DELEGATED DECISION TO DETERMINE APPLICATIONS FOR NON-MATERIAL AMENDMENTS

Reference No: **2026/NM/91183/E**

Site Address: 98, Listing Lane, Littletown, Liversedge, WF15 6EZ

Description: Non material amendment to previous permission
2024/90423 for erection of two storey side extension

Drg No 24 13 Rev A

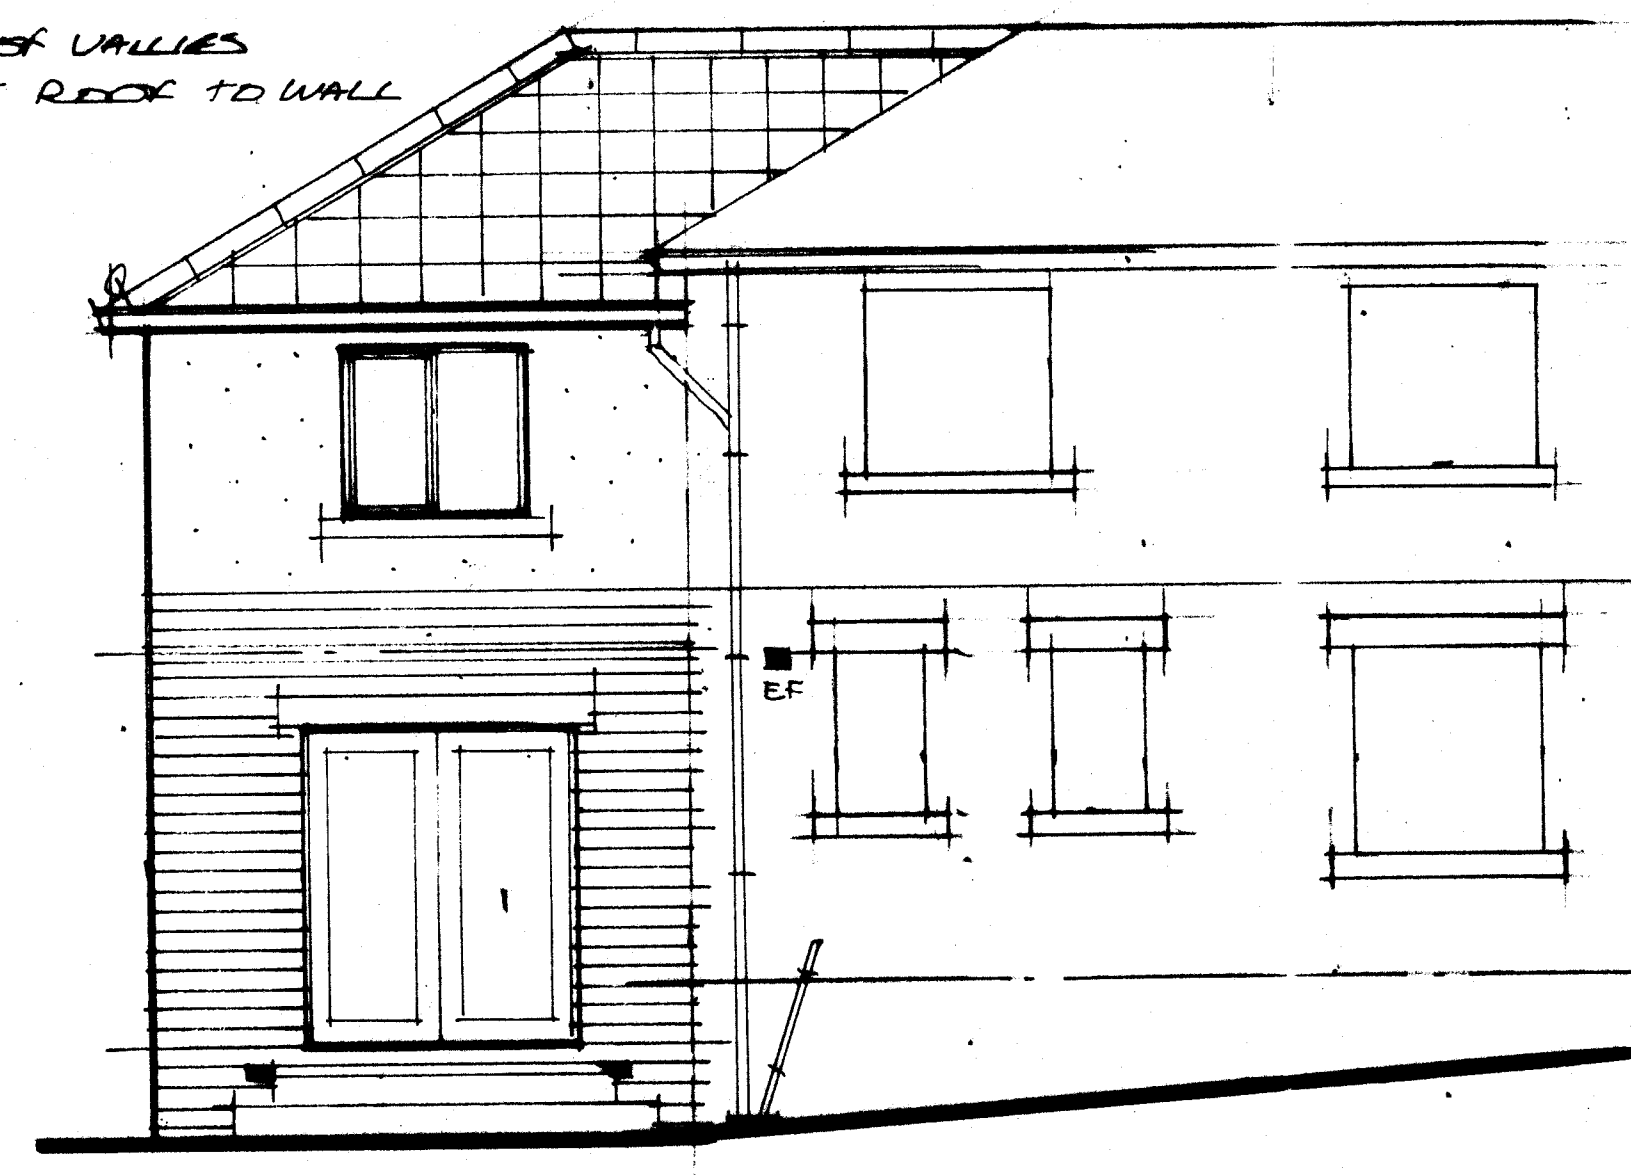
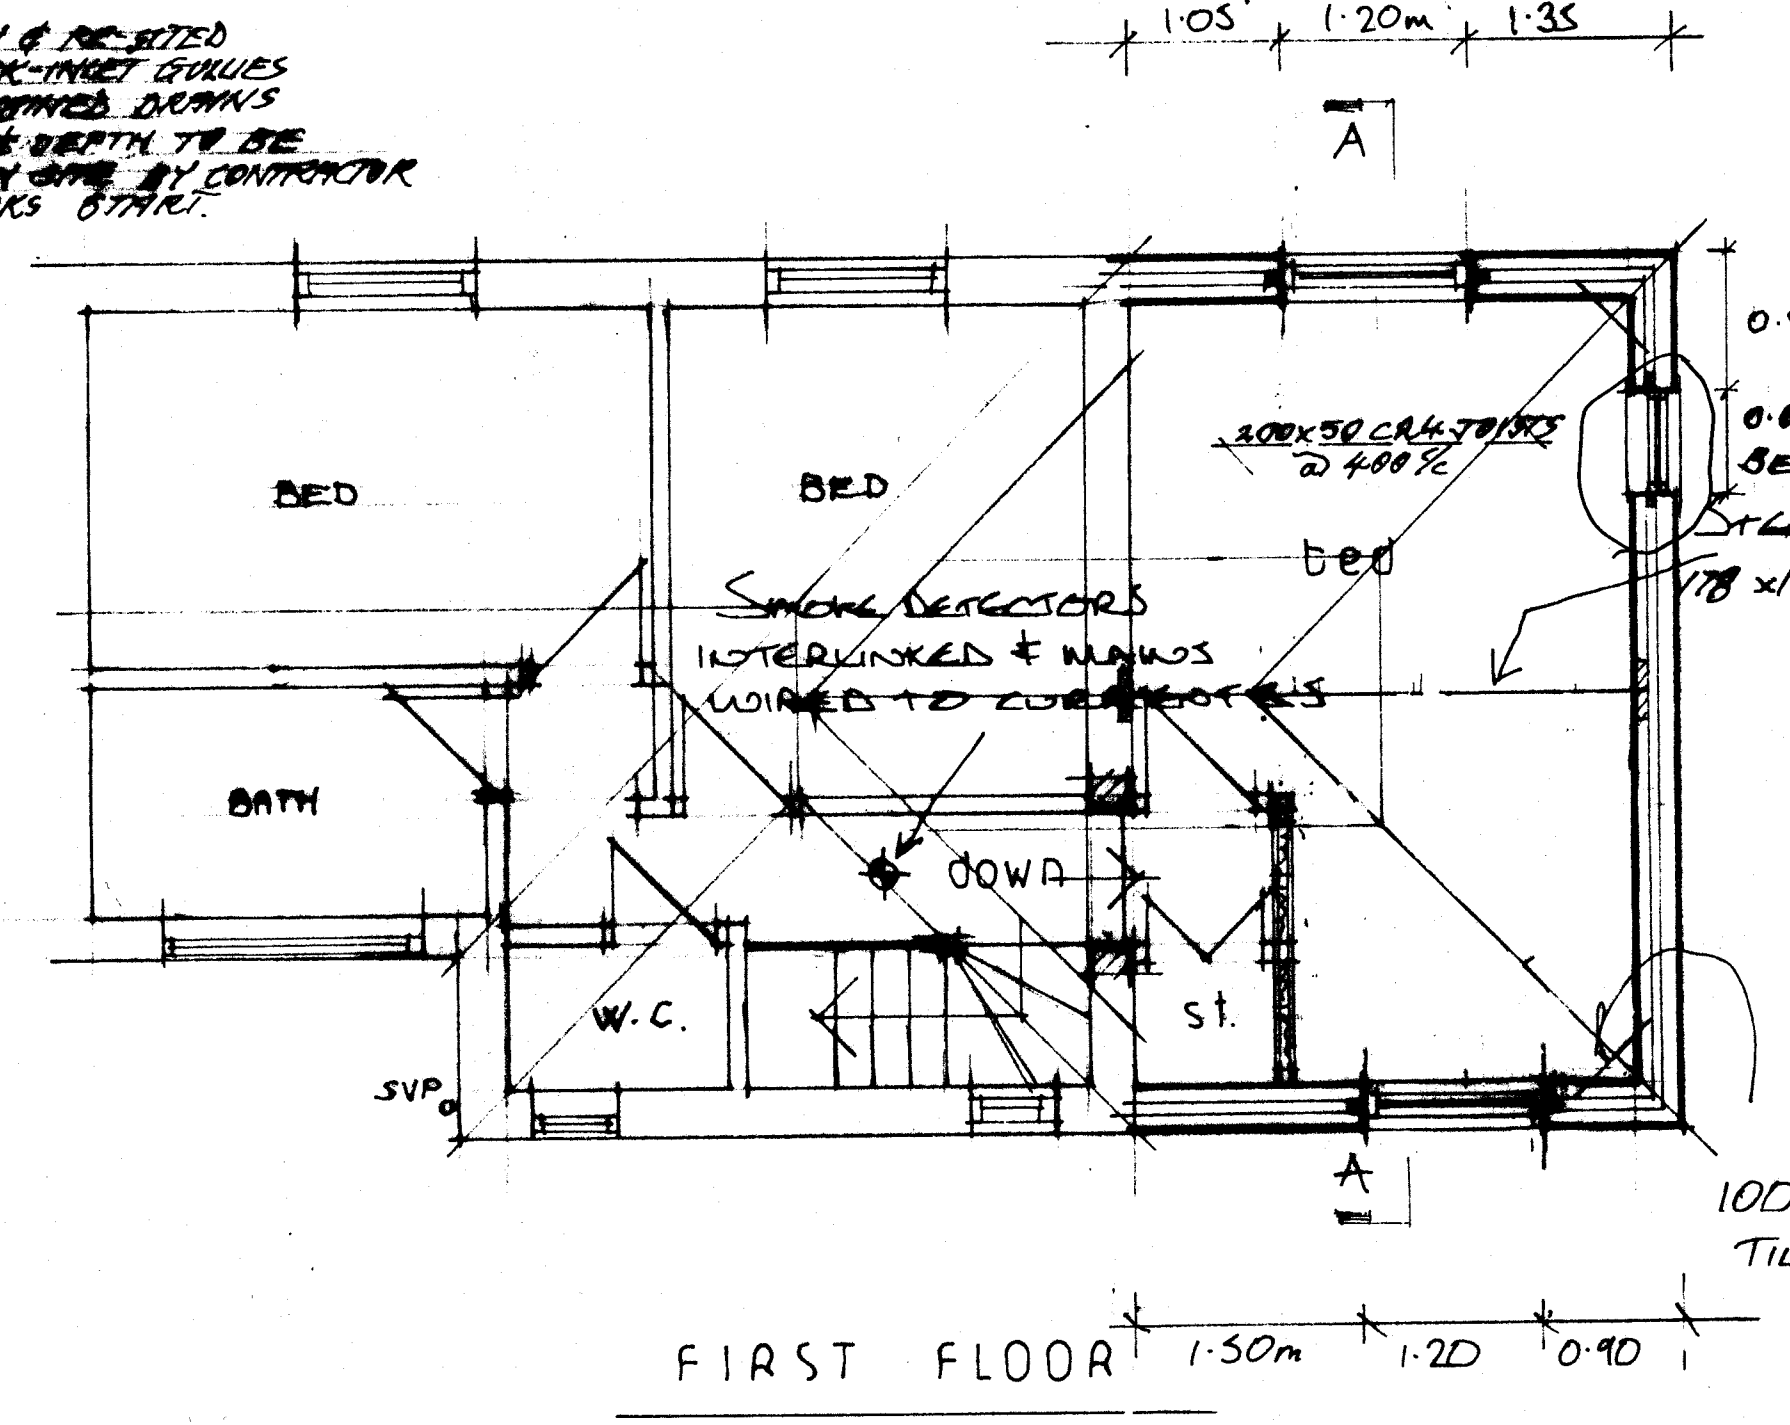
The amendment seeks to include a first floor window in the side elevation.

All materials are to match those of the host building as per the existing approval. The new window would serve as a secondary bedroom window overlooking their own garden area to the side. None of the original application's conditions are breached by the proposal, nor are any further conditions required for the amendments to be acceptable. No council policies are contradicted by the amendments.
